SCHEMATIC DESIGN ASSESSMENT

5-7 Church Street
Nelson Bay NSW 2315
20 January 2025

Construction of a new 10 storey apartment building incorporating a pool, communal areas, and carparking levels

5-7 Church Street Nelson Bay NSW 2315

Drawing Title
GA Plan - Basement 02

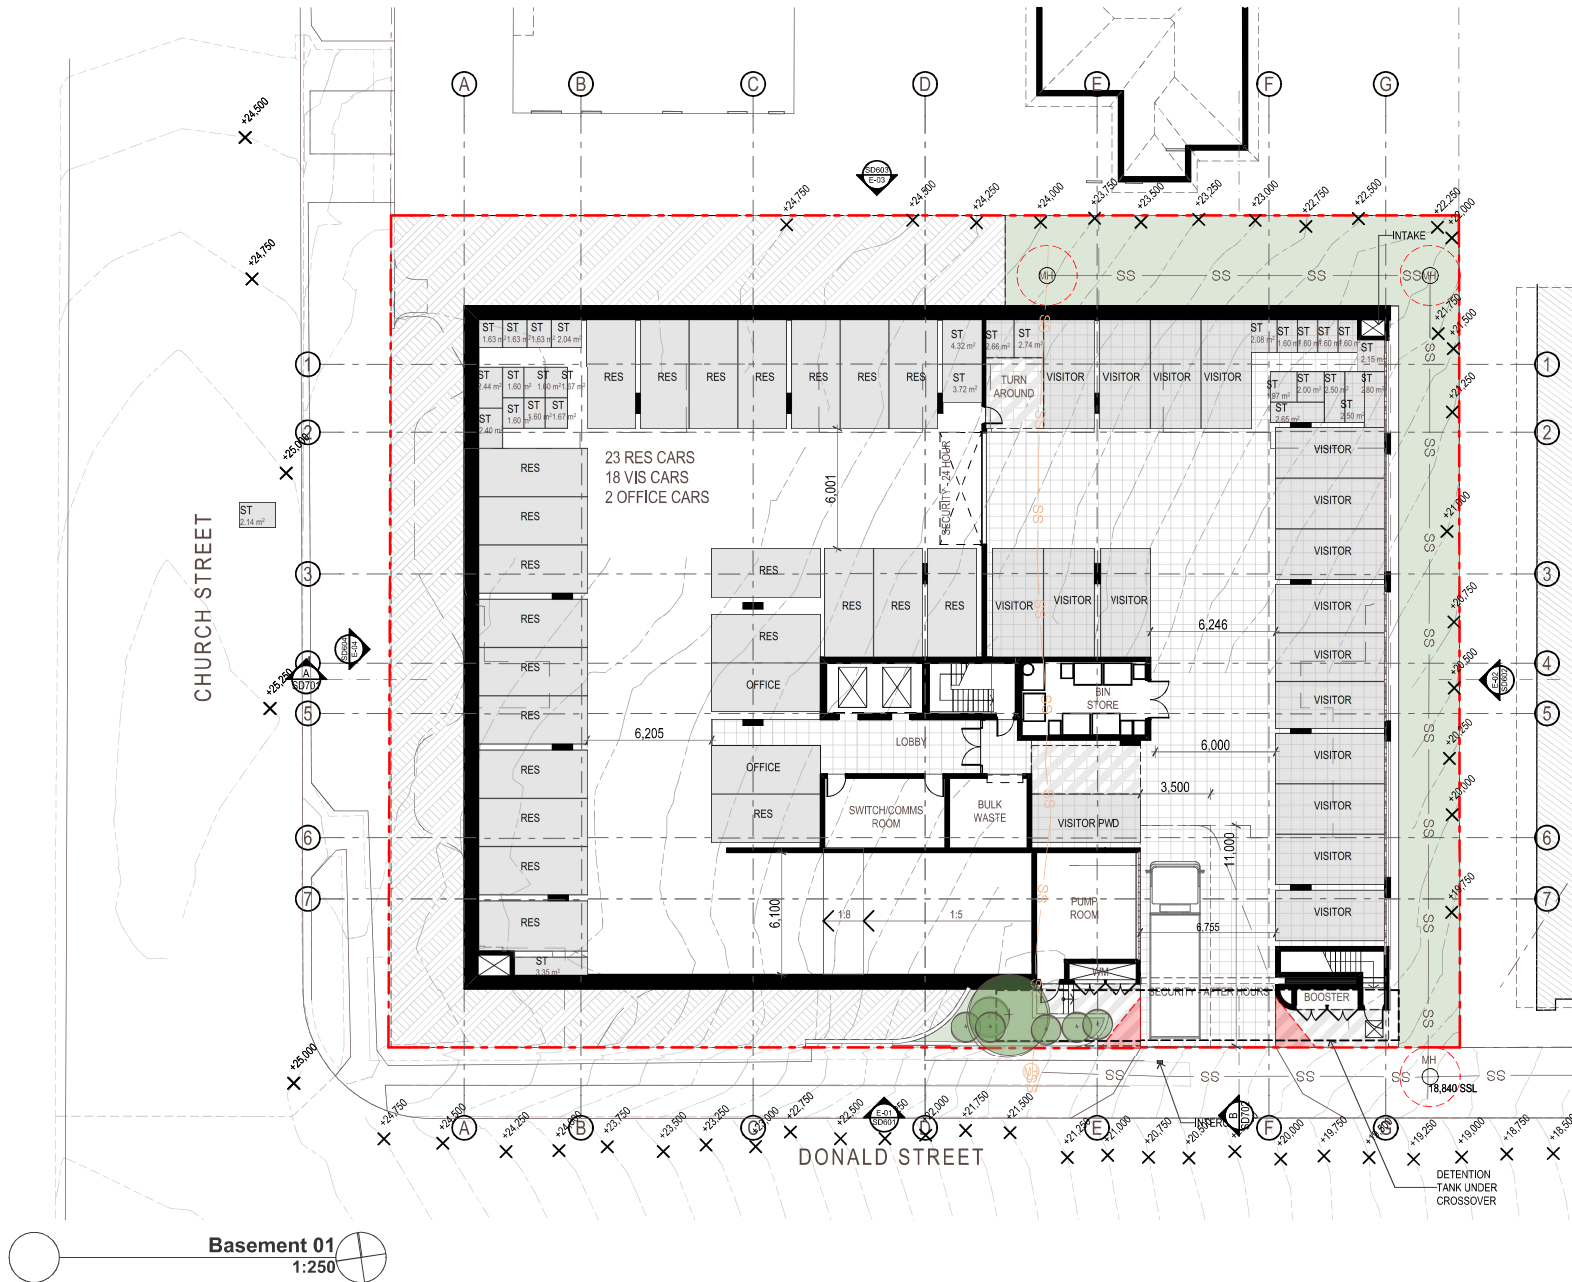
Clause	Further Comment
Part D2D5	The following areas have extended travel distances: • Basement level 02 – more than 20m to a point of choice from the western portion of the basement (39m) • Basement 01 – more than 20m to the road/open space from the western portion of the basement (60m) • Roof Terrace - 27m from the most remote point in the BBQ areas to the core in lieu of 20m • 14m in lieu of 6m for all apartment levels from the most remote SOU front door to the stair core
Part D2D6	Basement level fire isolated egress staircase discharge converges into basement level 01 egress pathway.to be justified via FER
Part D2D12	Fire safety engineer to justify the proposed FIS discharging within the building at basement level 01 in lieu of to a road or open space
Part E1D2- inter-alia AS2419.1 cl.6.11.2 – “Internal pump rooms”	It is proposed to have the fire pump room located on basement level 1 discharging internally (i.e. loading bay/lobby/driveway) in lieu of to a road or open space. Fire engineer to justify this departure.

Drawing Title
GA Plan - Basement 01

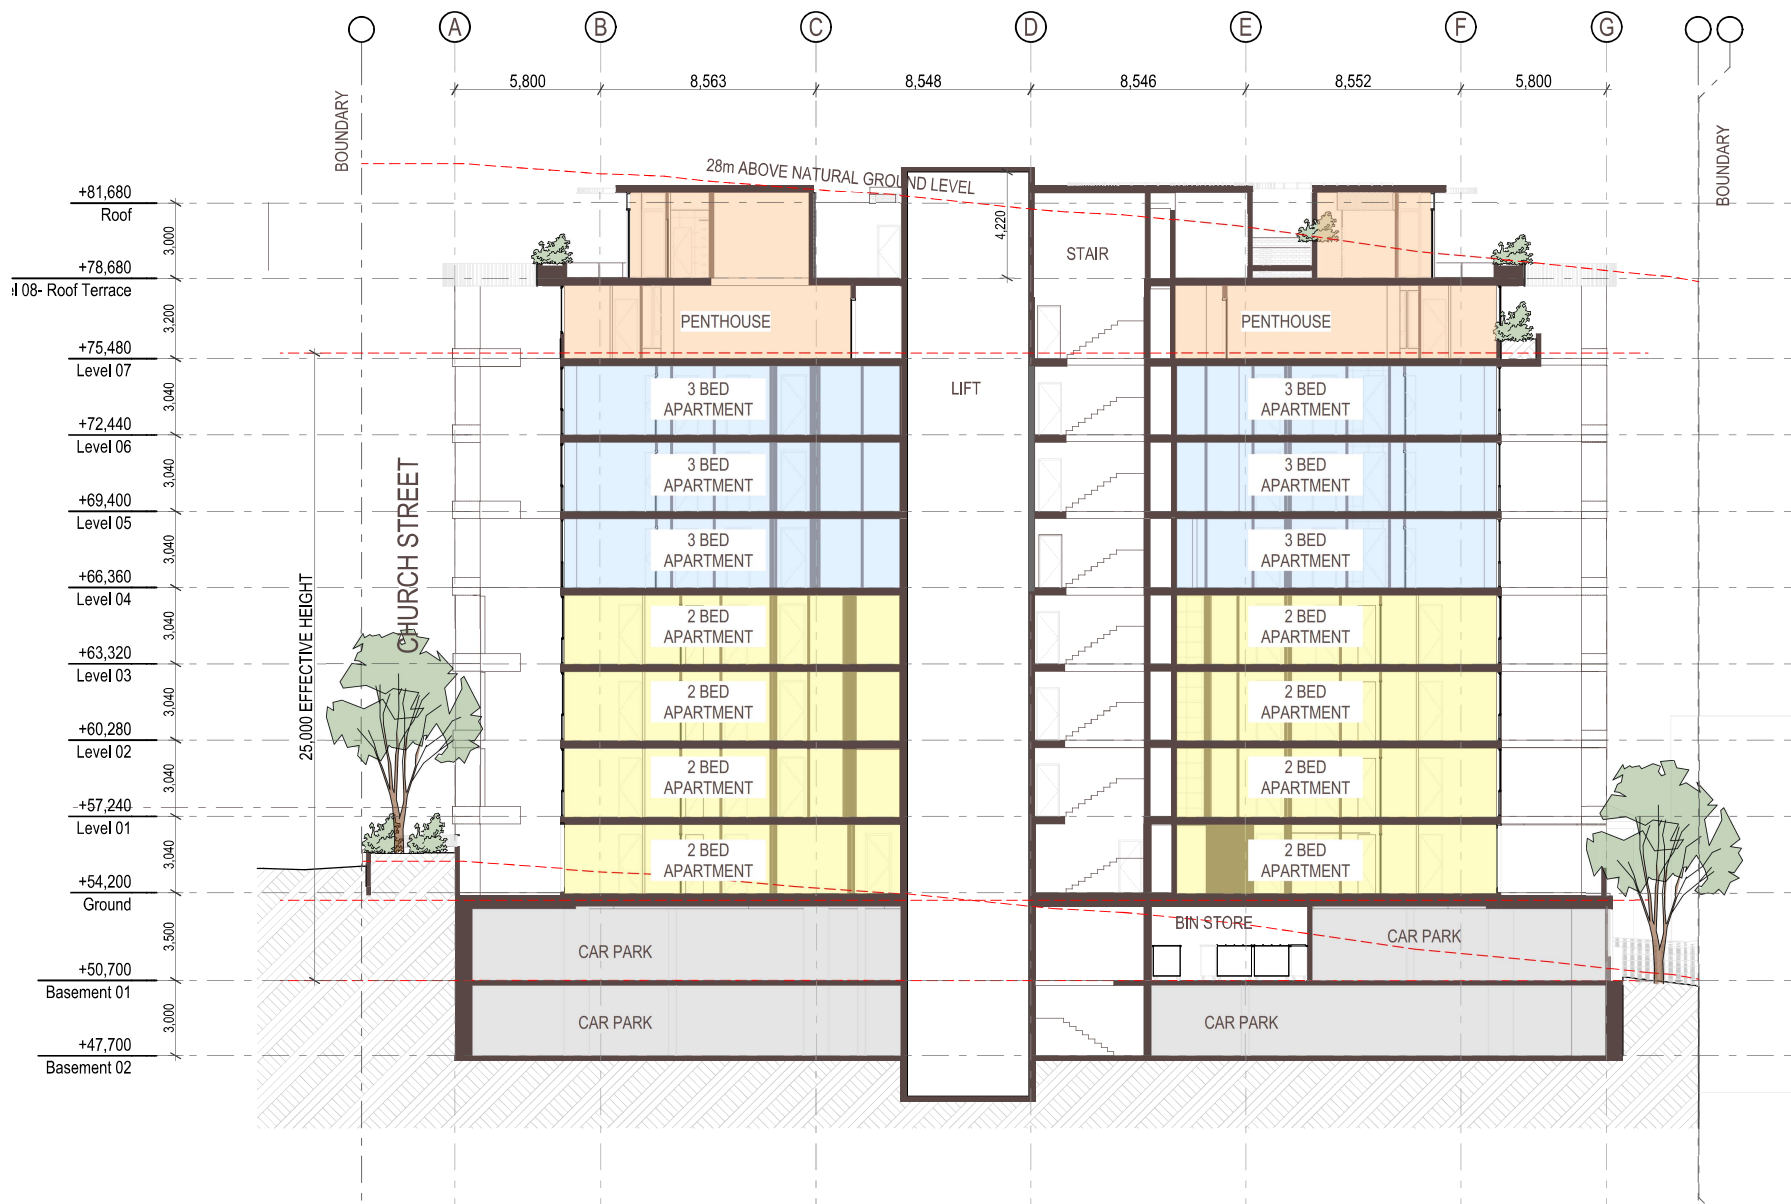
- ★ Part D2D6 (b) – Basement level fire isolated egress staircase discharge converges into basement level 01 egress pathway to be justified via FER

GA Plan - Roof Terrace

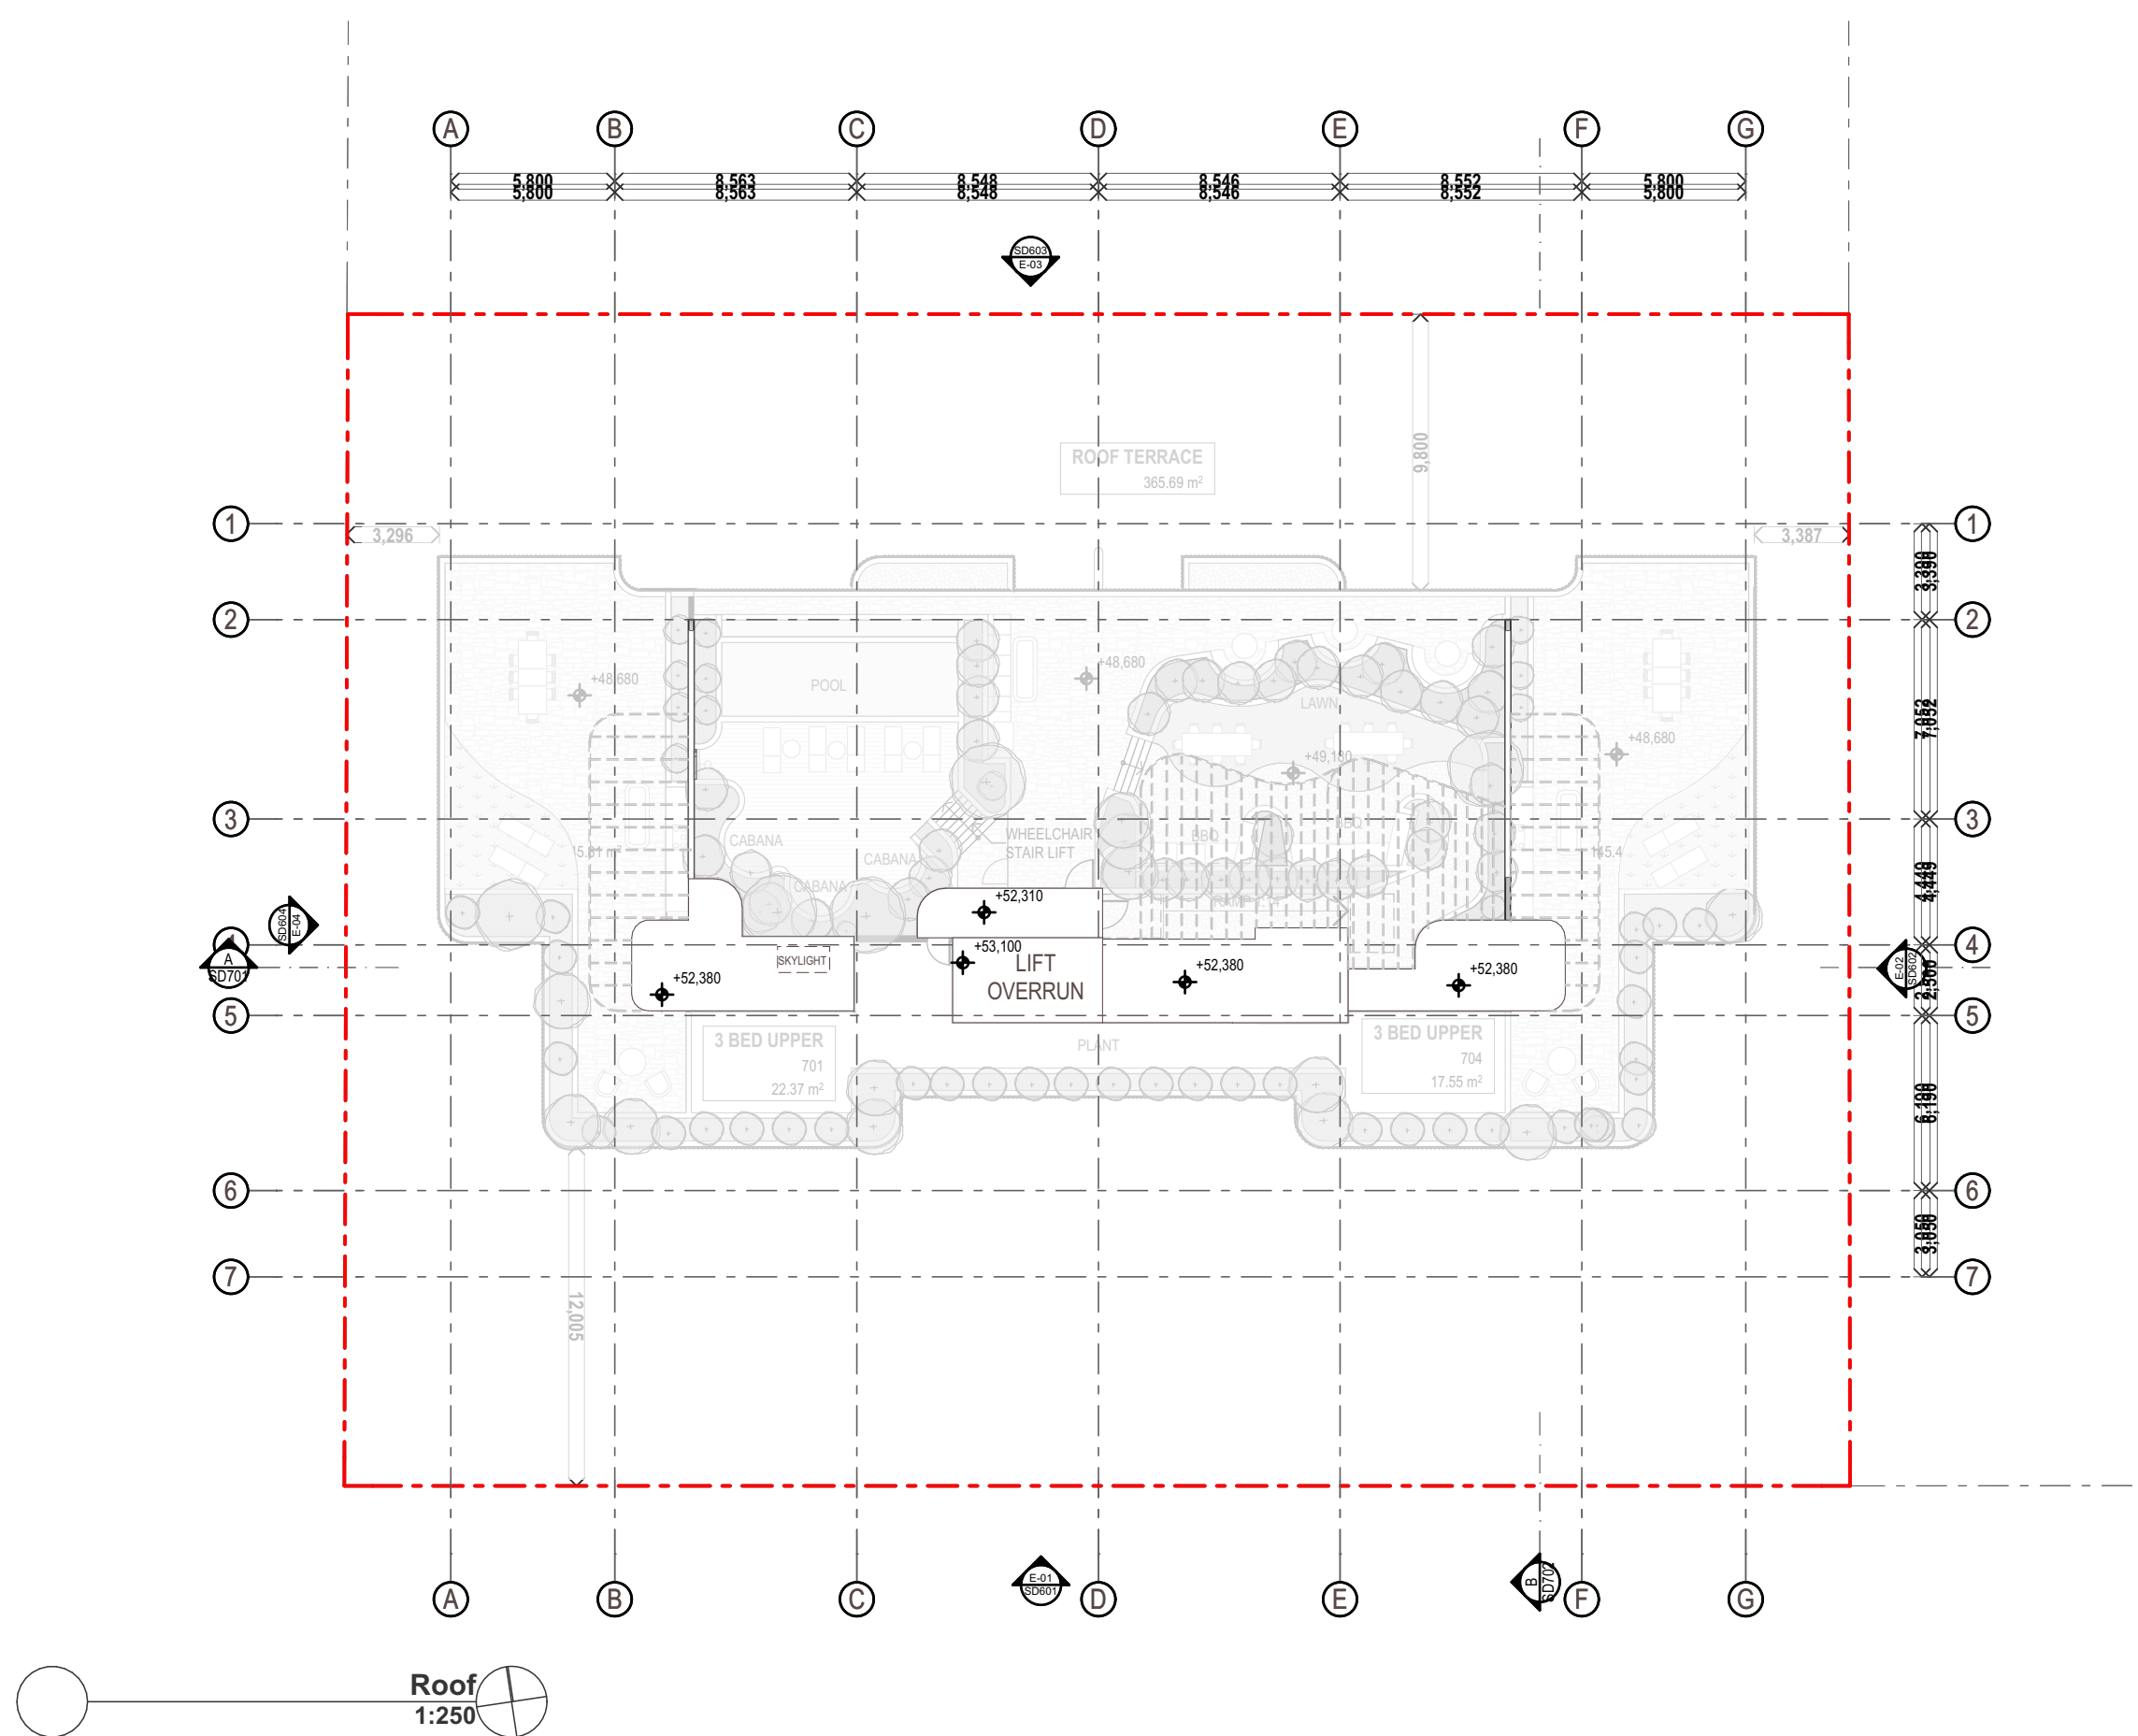
Item	Further Comment	Additional Info
	Provide an accessible path of travel from the roof terrace level into the BBQ and Pool areas in accordance with AS1428.1, with staircase and ramps to have handrails as per AS1428.1	
Part D4D7 Signage - Braille and tactile signage to be located and specified in accordance with this part	Braille signage (for people with disabilities) adjacent to exits on each level are required stating "Exit" and "Level" followed by the floor level number e.g., Level Ground, Level 1, Level 2, etc.	
Part D4D13 – Glazing on accessways	If no chair rail, handrail or transom, all frameless or fully glazed doors, sidelights and any glazing capable of being mistaken for a doorway or opening within Ground Floor lobby, it must be clearly marked per AS1428.1 i.e., glazing decals. Document in working drawings.	Typical details to be provided as part of Design Documentation.
Part E – Services and Equipment
